FORT HALSTEAD, CROW DRIVE, SEVENOAKS**AMENDED DOCUMENT PURSUANT TO HYBRID PLANNING APPLICATION
19/05000/HYB**

The proposed amendment is in relation to the demolition parameter plan, specifically the buildings proposed for retention and demolition within the QinetiQ 'X' enclave.

The Demolition Parameter Plan identifies buildings and structures proposed for demolition within the application boundary.

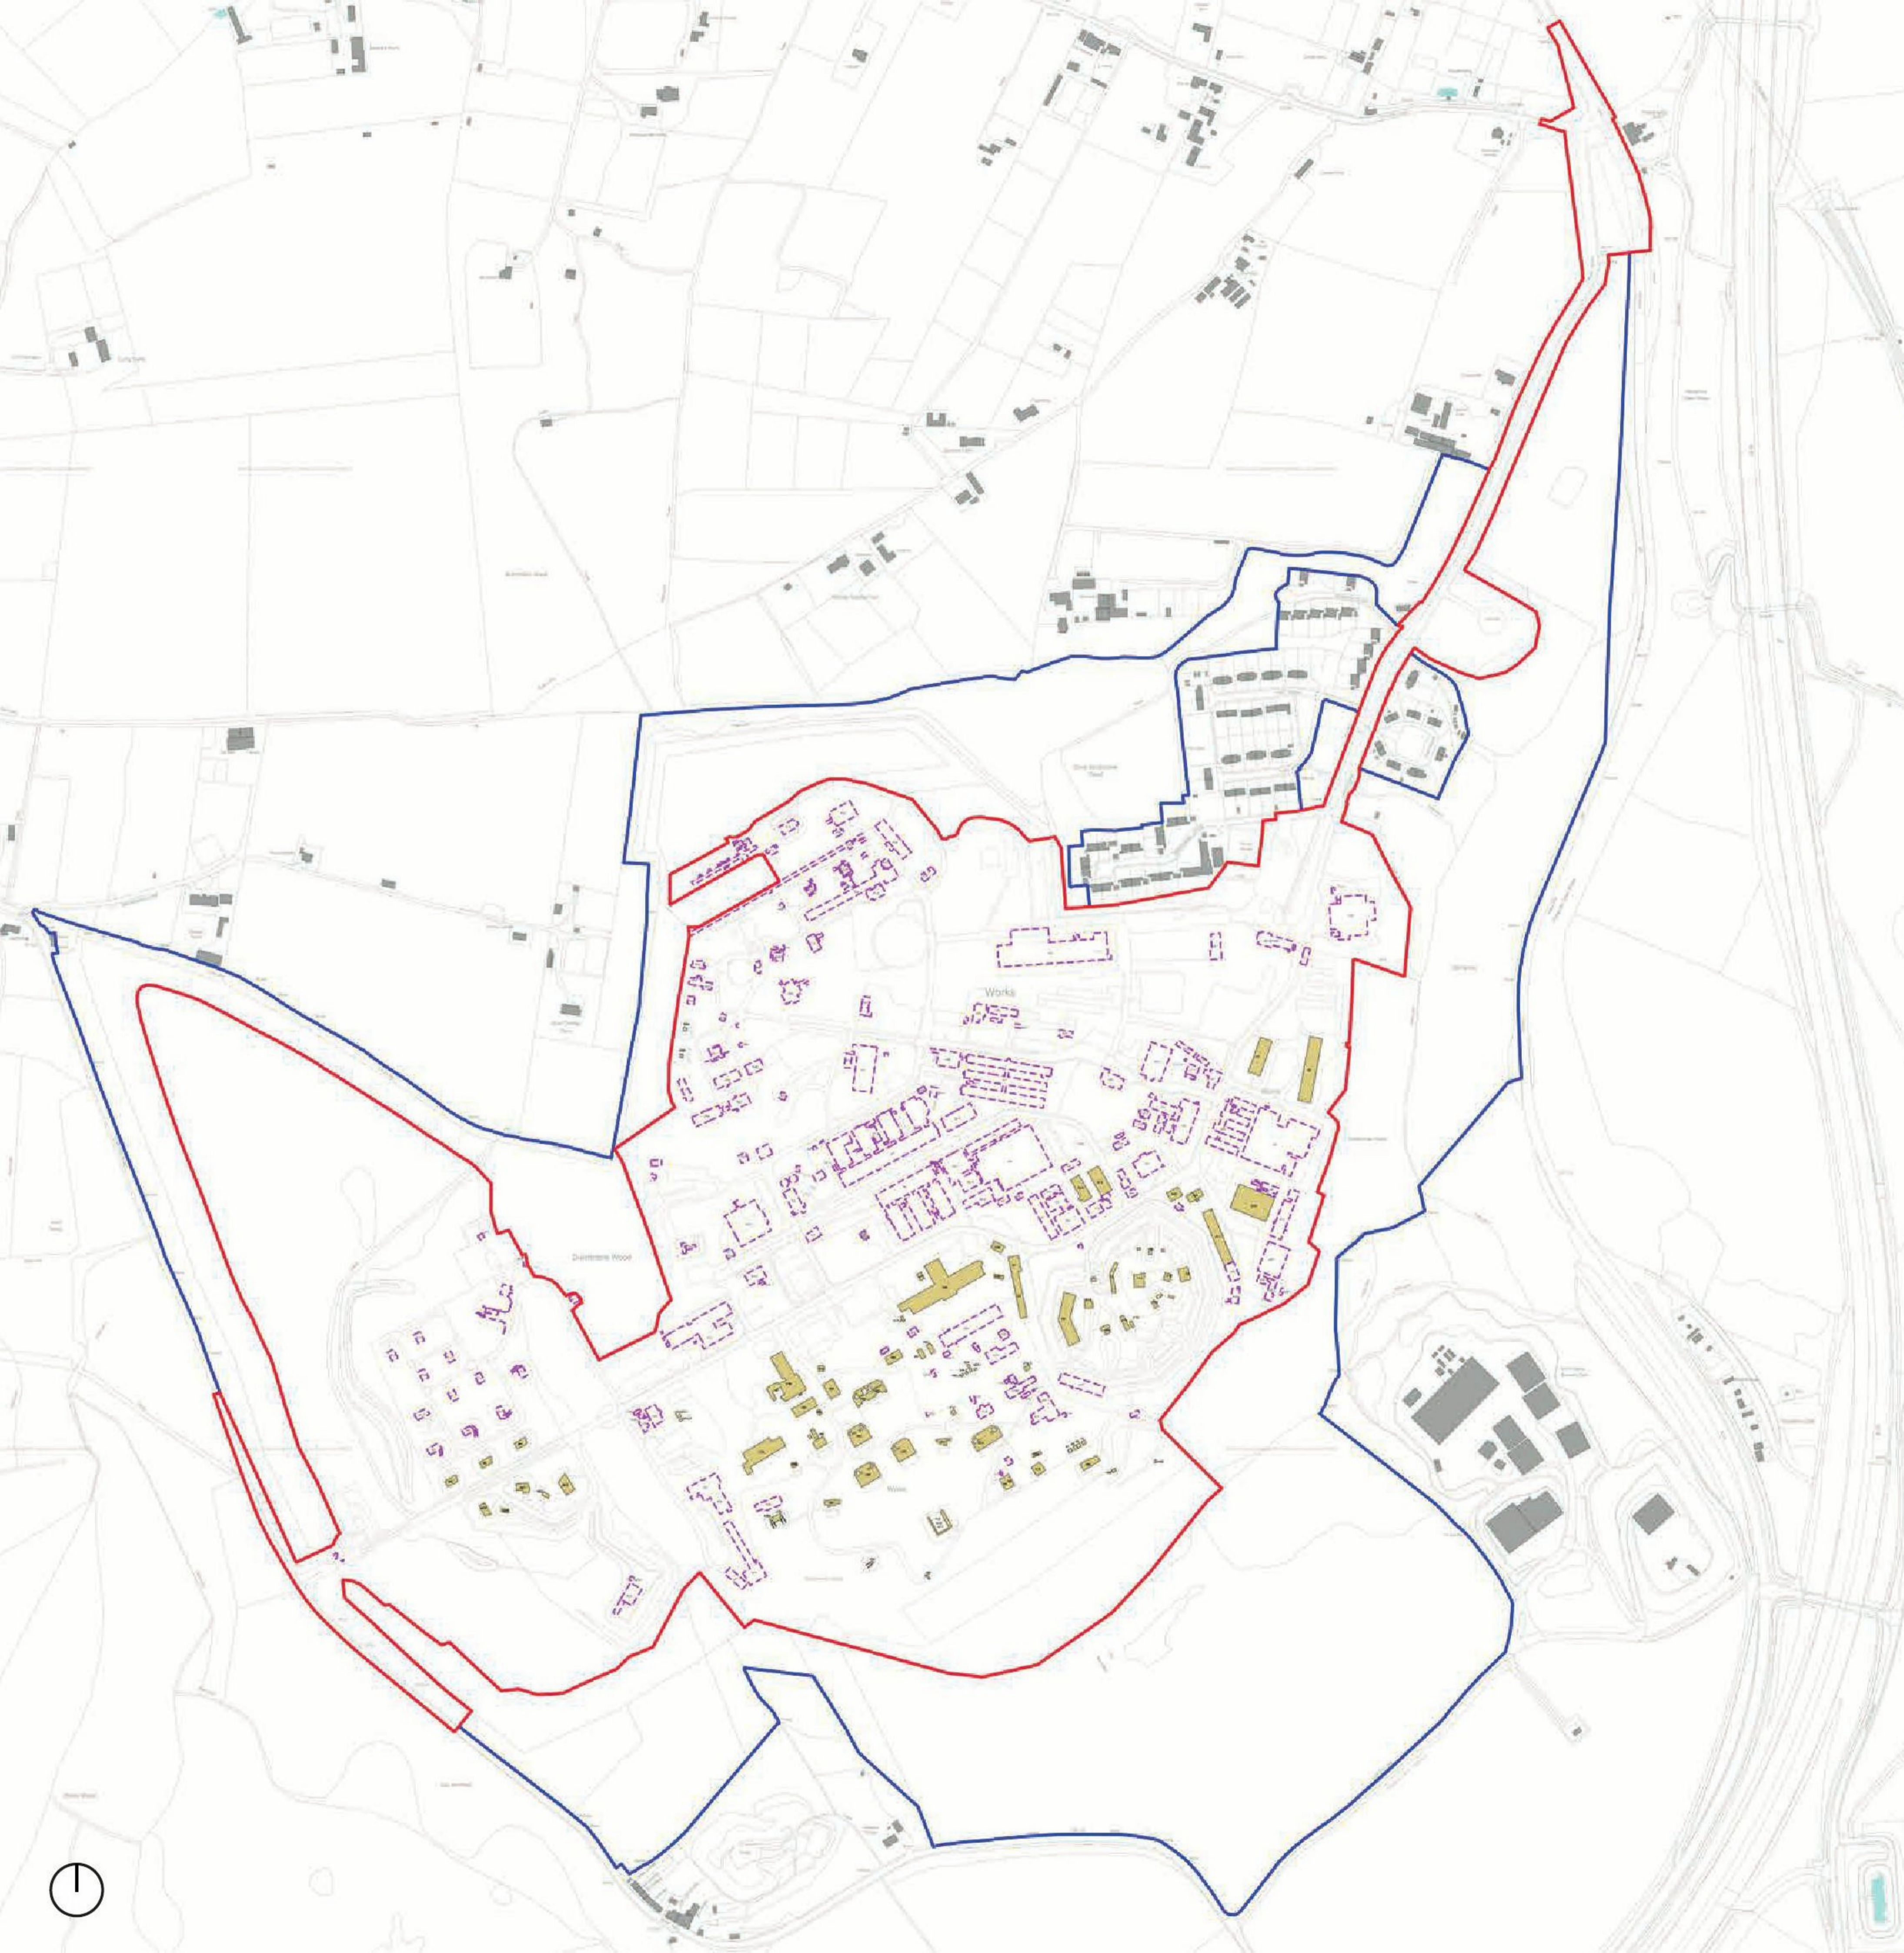
BUILDINGS TO BE RETAINED	SQM	BUILDINGS TO BE DEMOLISHED	SQM
X23	266.79	X43.1	22.53
X47	618.32	X43.2	6.45
X76	388.13		
X77	269.83

The proposed changes reflect the latest aspirations for QinetiQ at Fort Halstead in accordance with the business needs.
